Subject: 2026/90477 at location land adj, 482, Halifax Road, Hightown, Liversedge, WF15 8DX

Please see ecological commentary below:

Figure 3. Baseline Habitat of the site at Halifax Road.

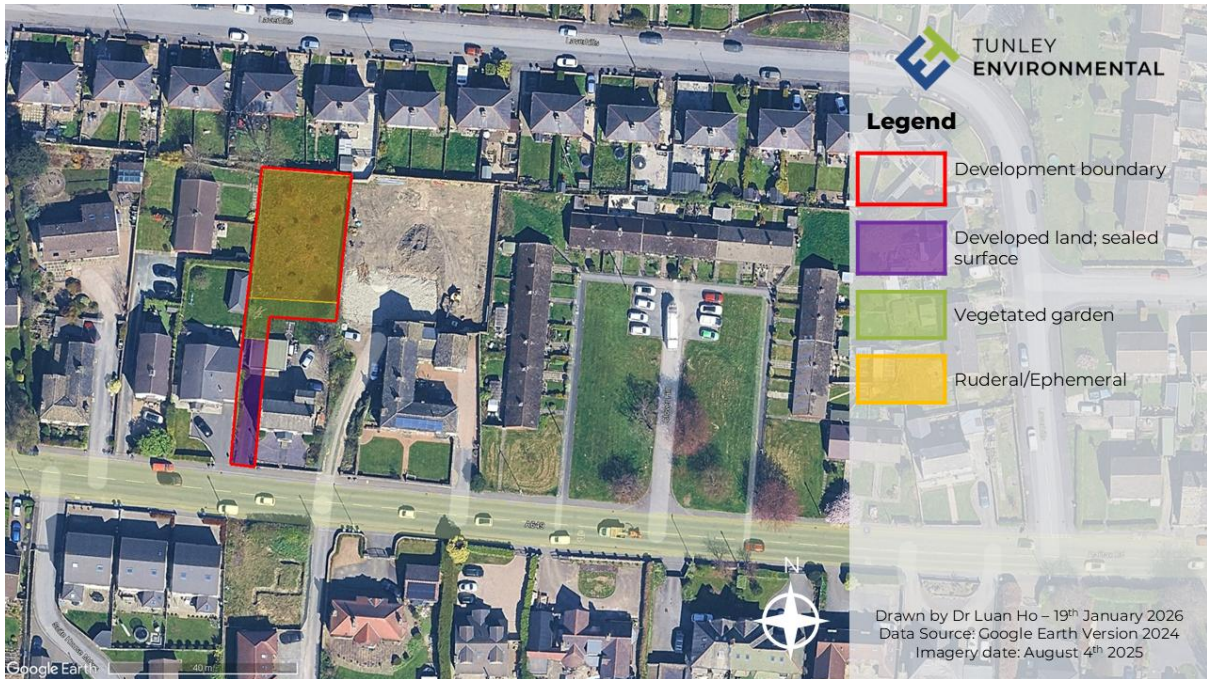
The BNG report does not confirm when a walkover survey was conducted, and there is no photographic evidence. As a result, the baseline credits cannot be validated when the metric based on the report is provided. There are also no pre/post development habitat plans.
